## **CITY OF PORTLAND**

### **STOP WORK NOTICE**

RE: 10 Wirt Street

CBL: 299-E-006

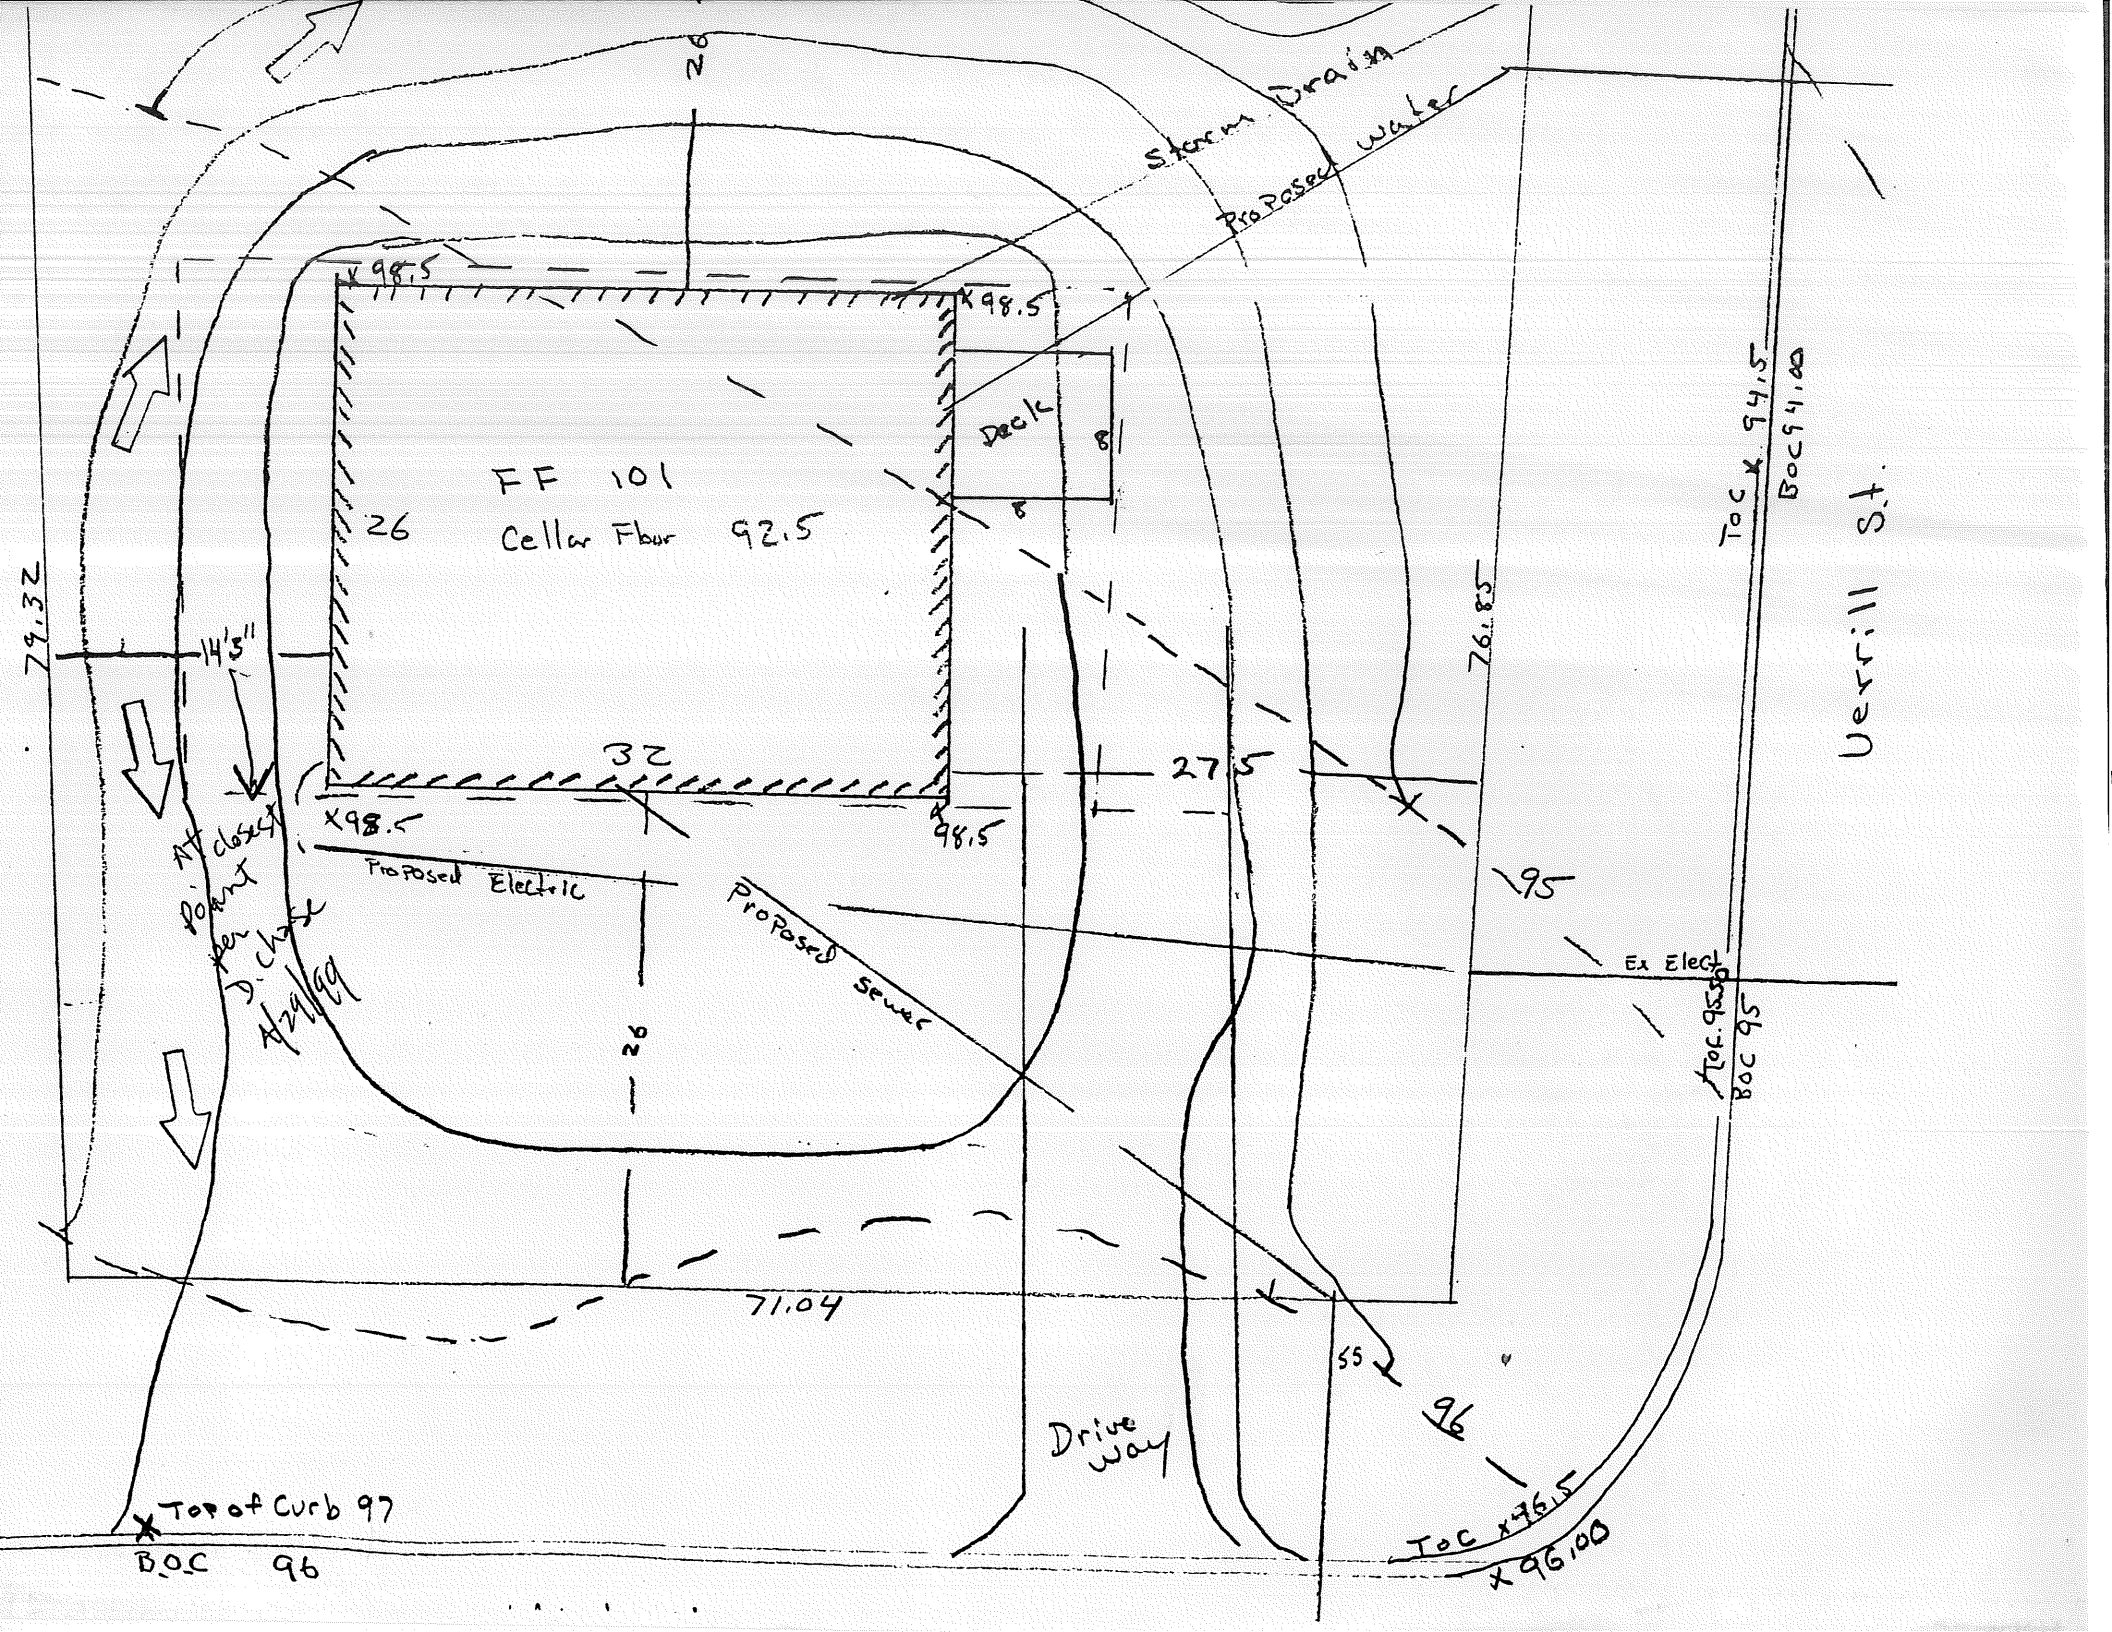
Submitted Site Plan boundaries undetermined

Survey property boundaries and locate proposed structure in accordance with City zoning standards.
